PLAN SNAPSHOT REPORT VAC-2025-00048 FOR CITY OF ALBUQUERQUE

Plan Type: Vacation	Project: PR-2020-004622 (PR-2020-004622)	App Date: 11/06/2025
Work Class: Public Easement(s)	District: City of Albuquerque	Exp Date: NOT AVAILABLE
Status: In Review	Square Feet: 0.00	Completed: NOT COMPLETED
Valuation: \$0.00	Assigned To:	Approval Expire Date:
Description: UNM South Campus Vacation of 120' Drainage Easement Tract 7 PR-2020-004622

Development Facilitation Team (DFT) – Review Comments

DRB Project No: PR-2020-004622 Date: 07/2/2025 Agenda Item: #7 Zone Atlas Page: L-15

(A REPLAT OF TRACTS 6, 7, 8, 9, & 10,
UNM GIBSON COMMERCIAL DISTRICT)
SECTION 28, T. 10 N., R. 3 E., N.M.P.M
ALBUQUERQUE, BERNALLILO COUNTY,
NEW MEXICO
NOVEMBER, 2025

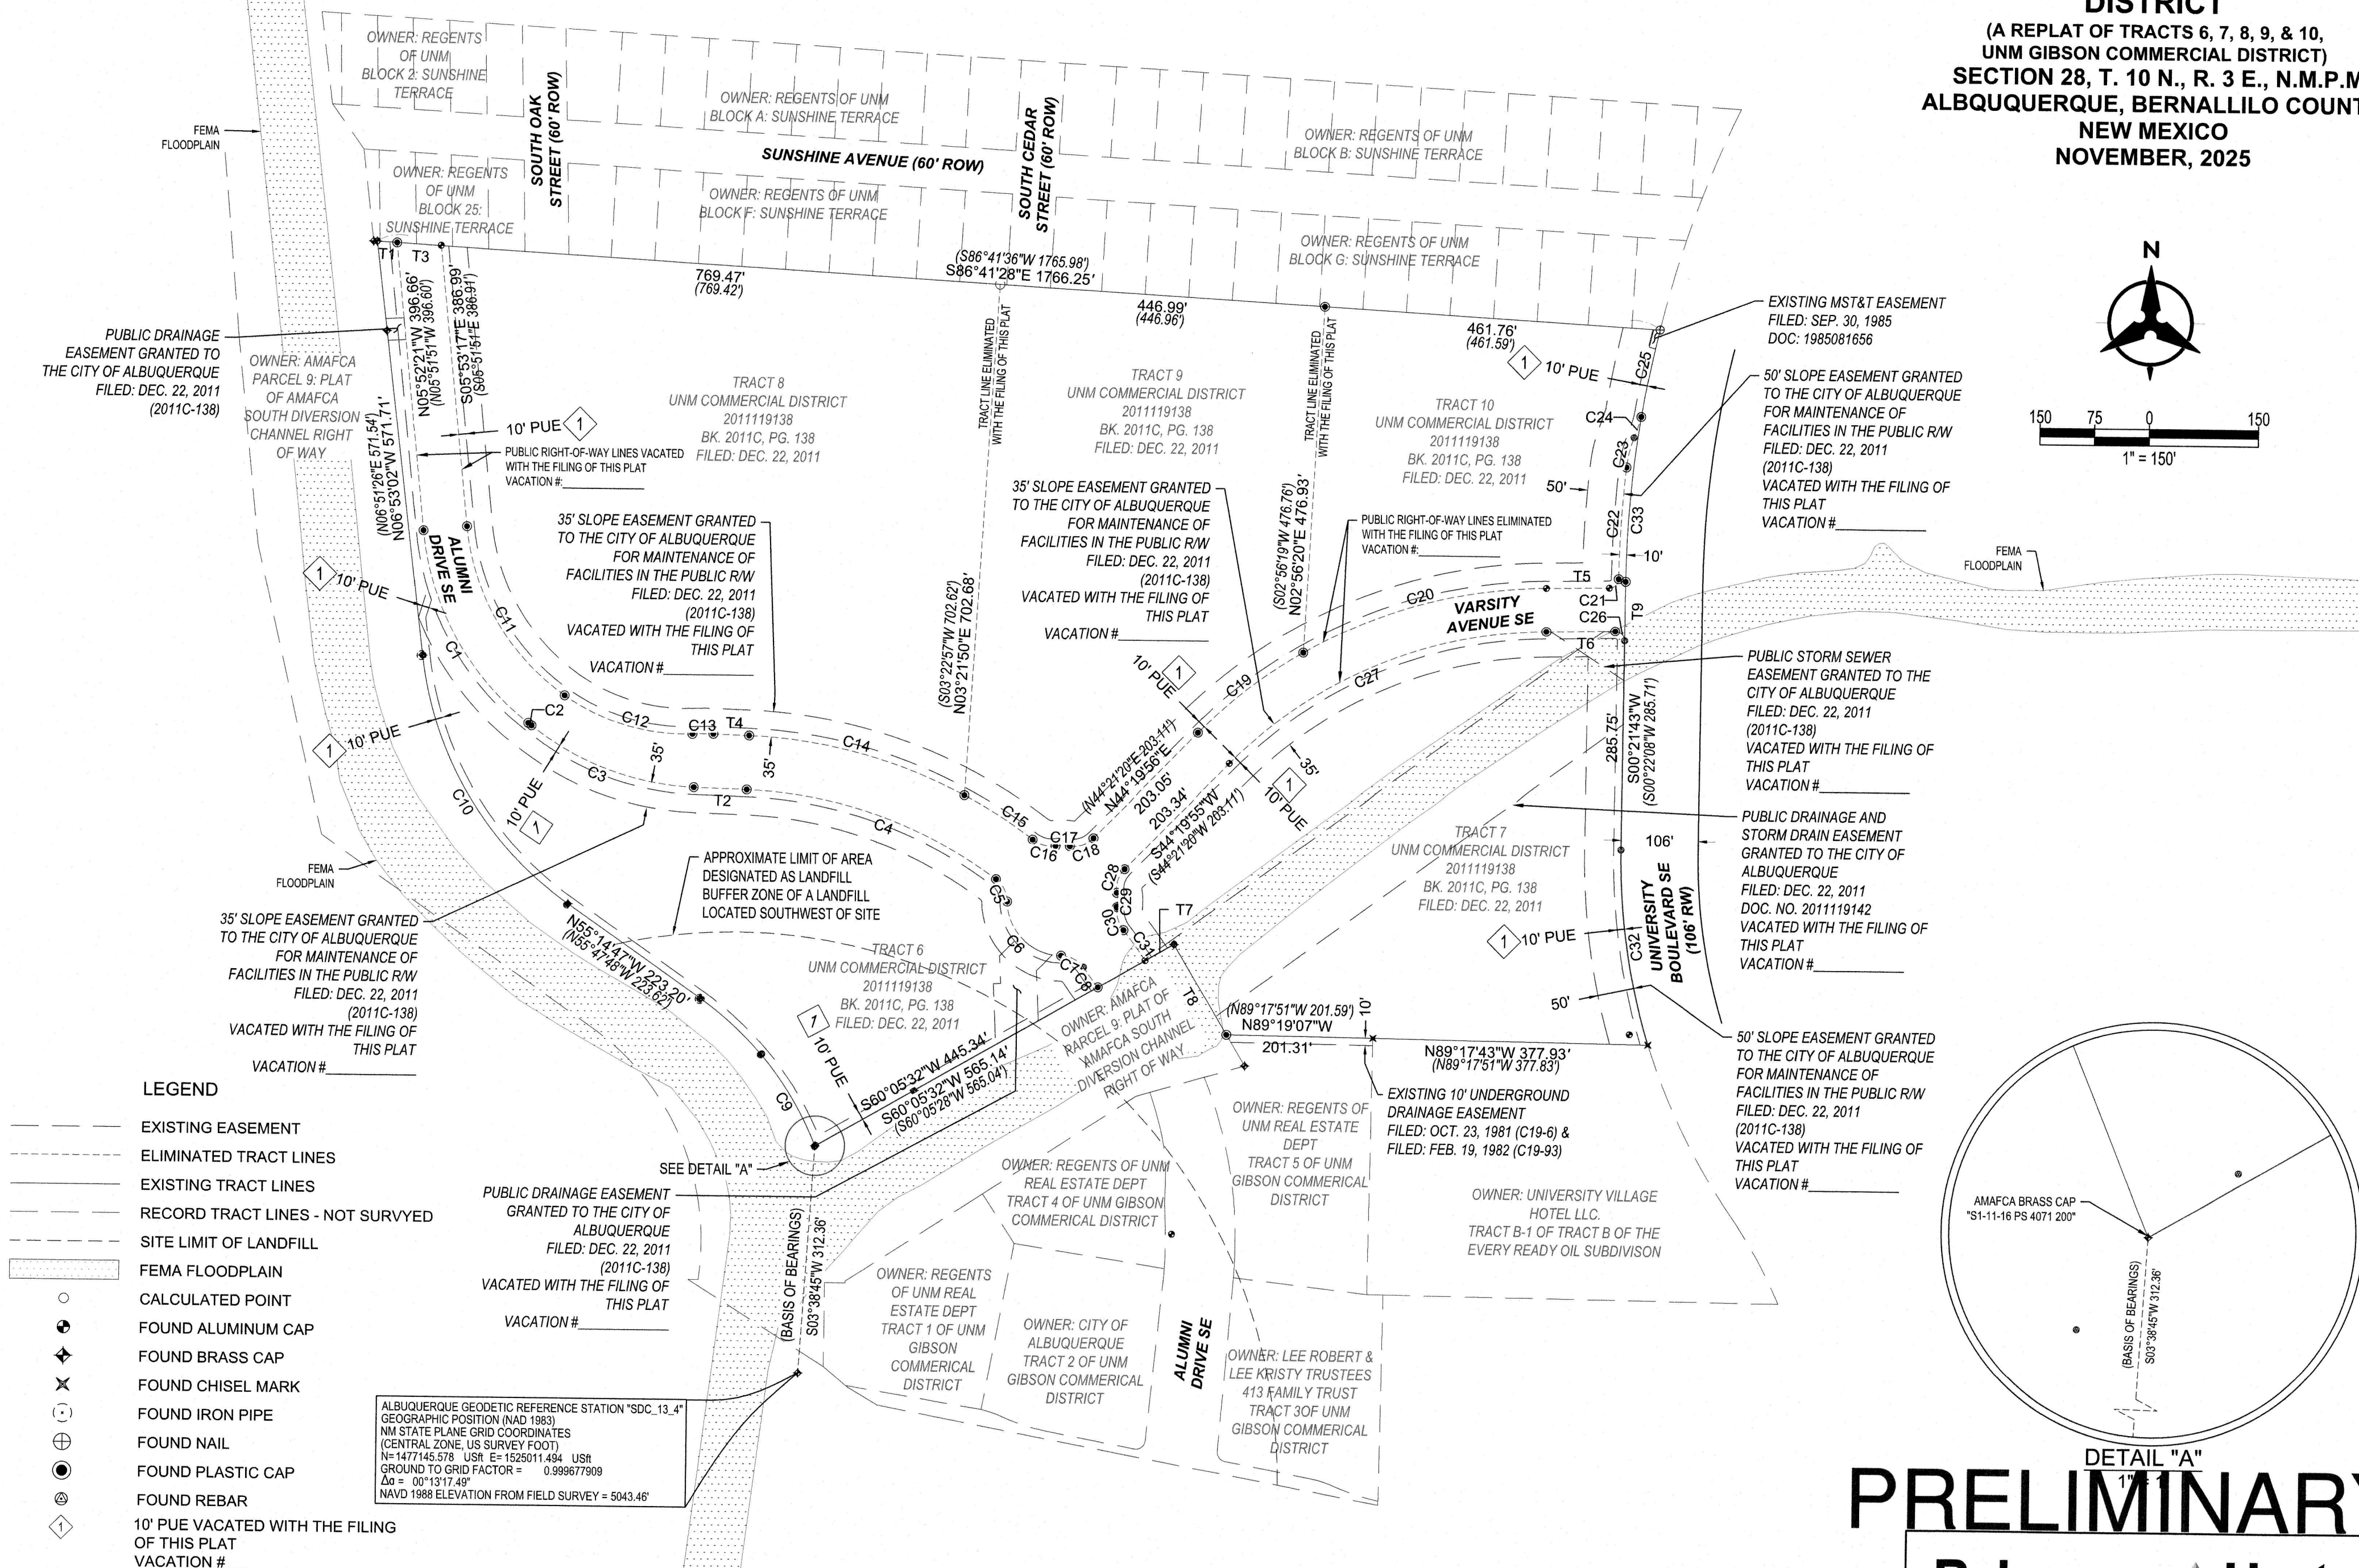
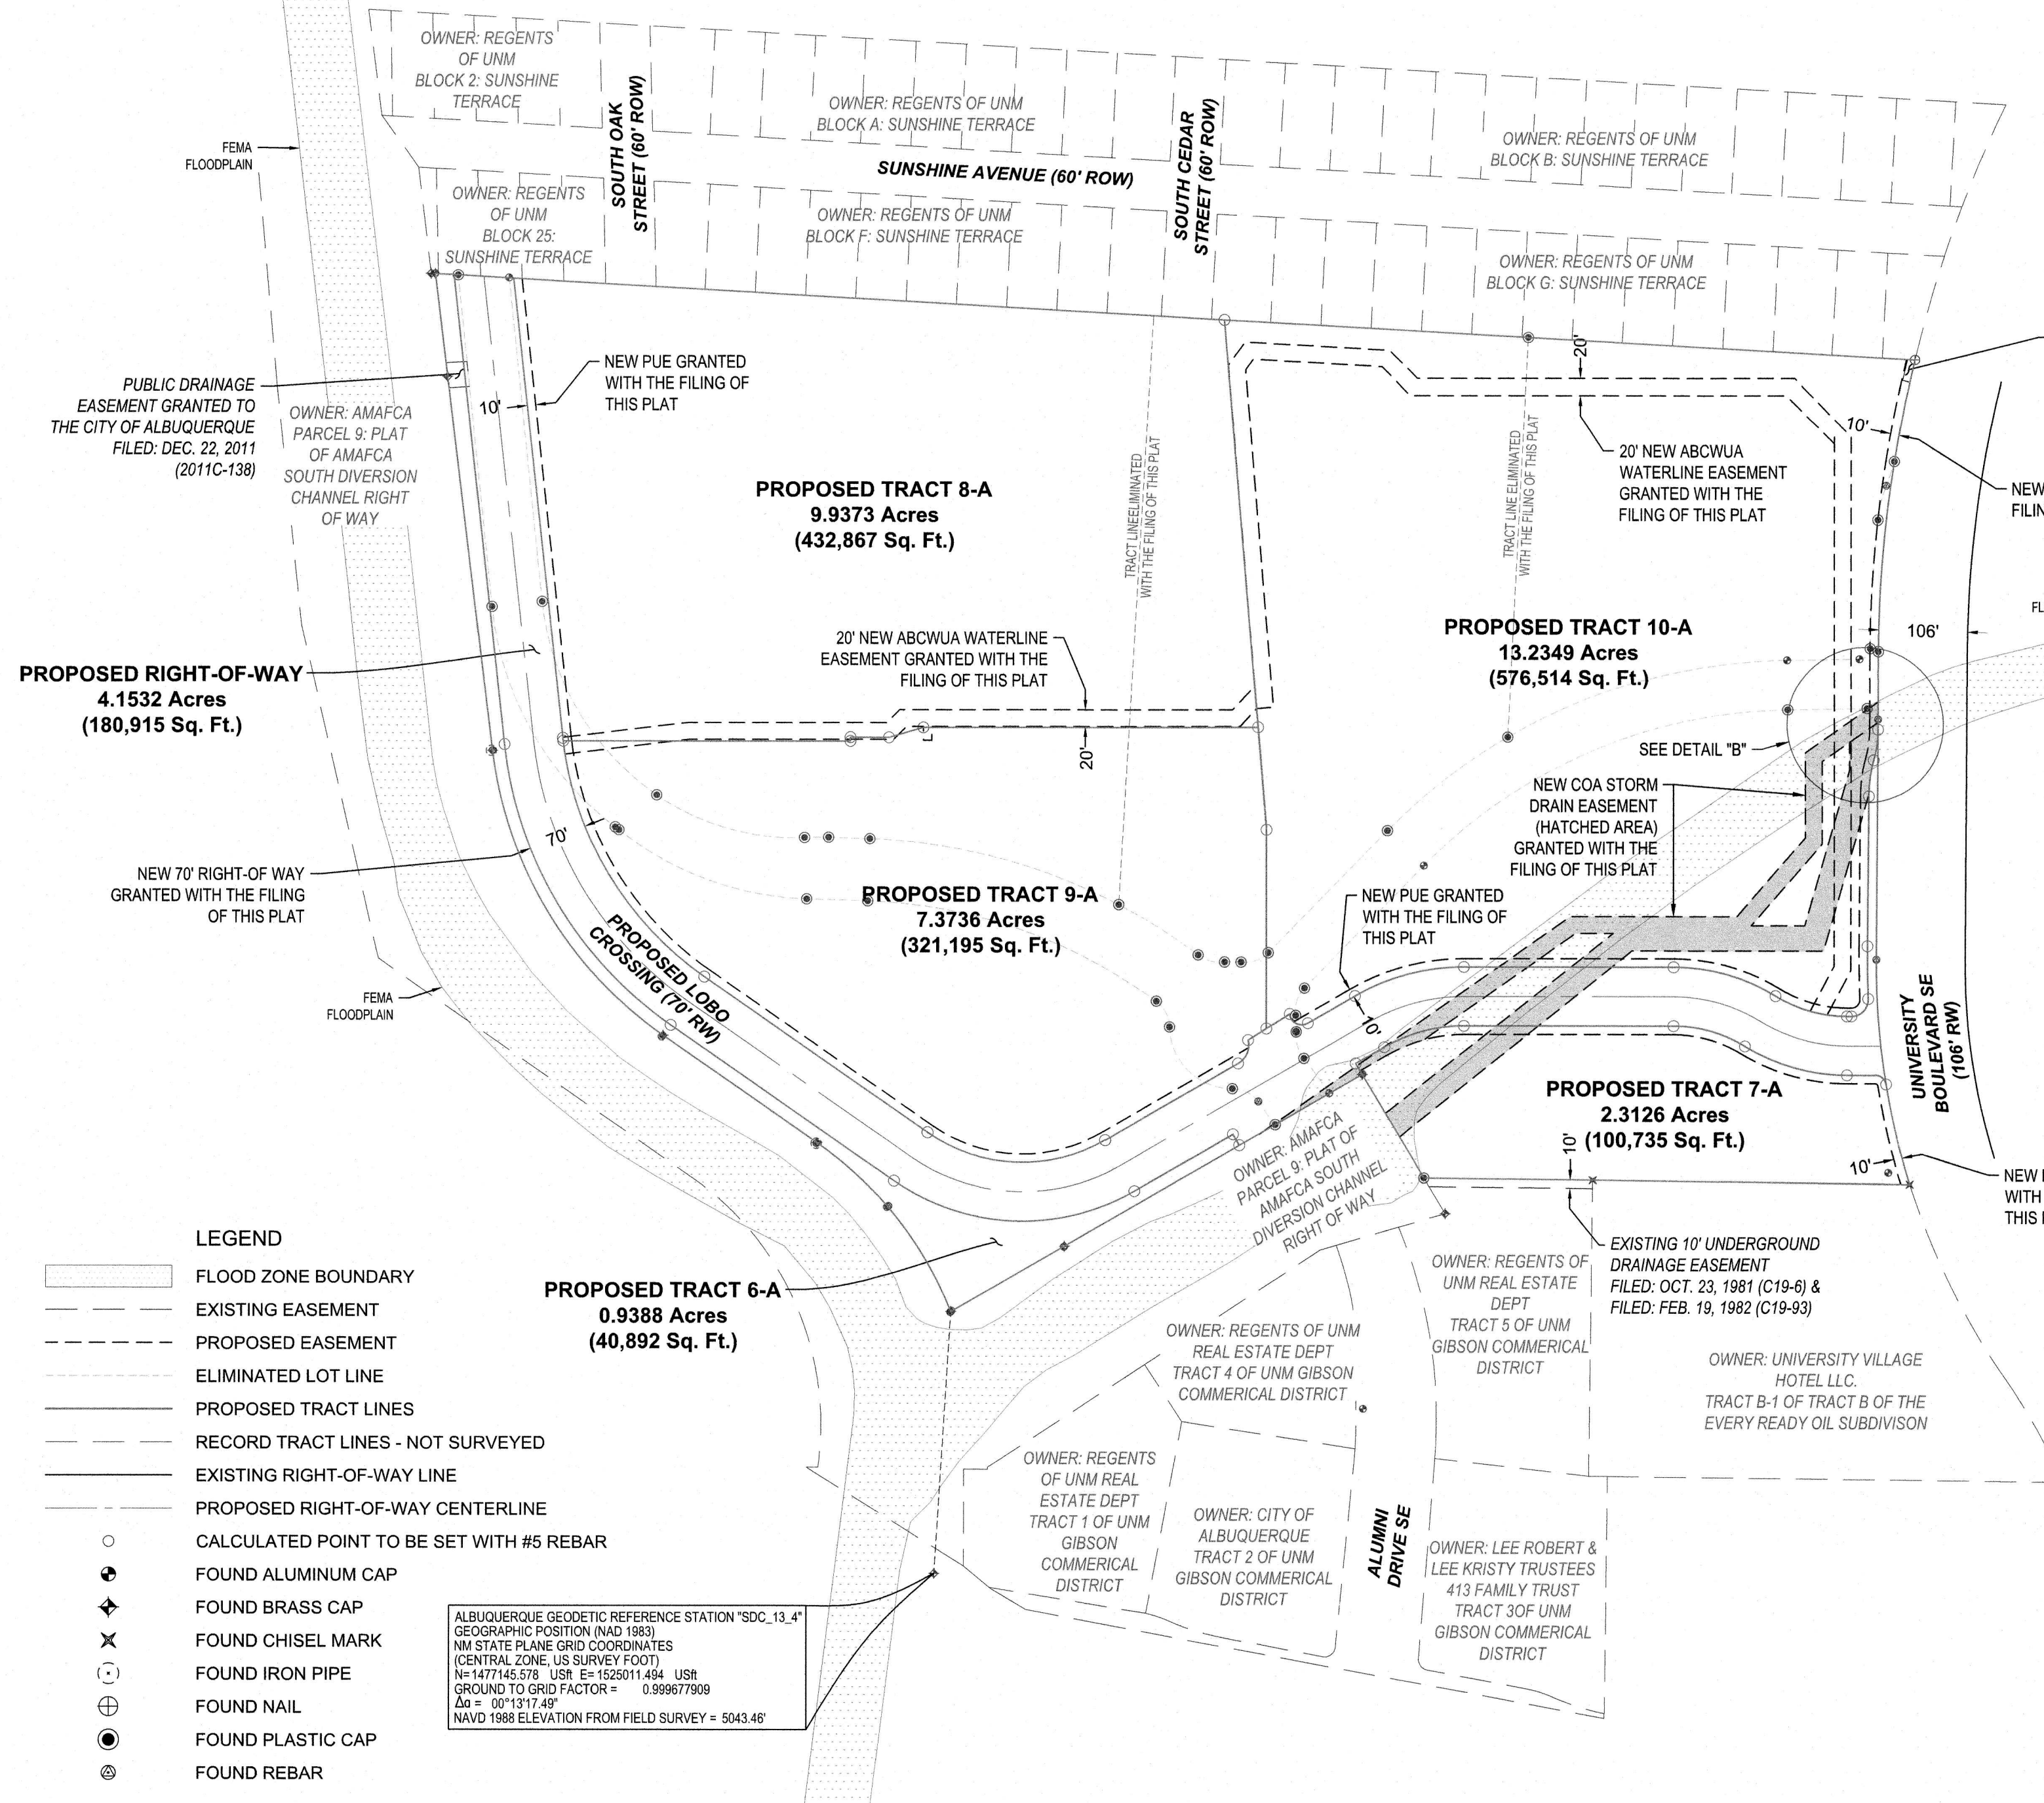
1. There is currently a Request for Availability (241203) that is being researched and will provide conditions for service.
 - a. This area is at a pressure zone boundary and infrastructure improvements will need to be coordinated closely with the Water Authority on how to service each proposed structure.
2. There are infrastructure improvements that are necessary to provide access to public water and public sanitary sewer however a site plan with proposed structures are important to understand to ensure the correct infrastructure is being required to service the entire site correctly.
3. If all infrastructure will be within public right-of-way, there is no need for additional easement notes however if there are, please add the following note to the plat.

- Is the proposed new ROW intended to contain the planned multi-use paved trail identified on prior infrastructure agreements? If so, please coordinate alignment with Parks and Recreation including updated trail crossing to Geneva's Arroyo (City Park property) to the east, which is currently at 95% design and will include trail. DMD is currently holding community meetings around a plan to improve the corridor along Buena Vista located east along the subject site.

- Hydrology has a legacy Conceptual Drainage Plan for the Mulberry and Gibson Development with an engineer's stamp dated 06/12/2002.
- An updated Conceptual Grading & Drainage Plan and updated Drainage Report is required prior to approval of the sketch plat.
- Hydrology has no objection to the Vacations.

1. Alumni and Varsity are both local roads and will require 5' sidewalk and a 4' landscape buffer. Transportation has no objection to the realignment of roadways and lot lines.
2. An approved TCL and TIS will be required prior to site plan or building permit. The TIS has been submitted and is in review.

- There is an AMAFCA diversion channels on the subject lots. The applicant's note suggests a release/removal of the AMAFCA channel. Reach out to AMAFCA for future platting action. See AMAFCA comment sheet. AMAFCA signatures are required for any platting action.

- A Sensitive Lands analysis is required prior to a future platting action for the subject property due to the presence of arroyos and possible steep slopes on the subject property:

- This Sketch Plat request also features vacated easements, including 35' and 50' slope easements along Alumni Dr SE and Varsity Ave SE, a 10' PUE, and existing Public Drainage Easements. There are two easements that are proposed to be vacated with a plat to then later be granted again with a paper document once the plat is recorded, they include a 20's storm sewer easement and a 100' existing drainage easement currently going through Tract 7. These proposed easement vacations will require DHO approval prior to or concurrently with the future platting action, and must provide justification per 6-6(M)(3) of the IDO as follows:
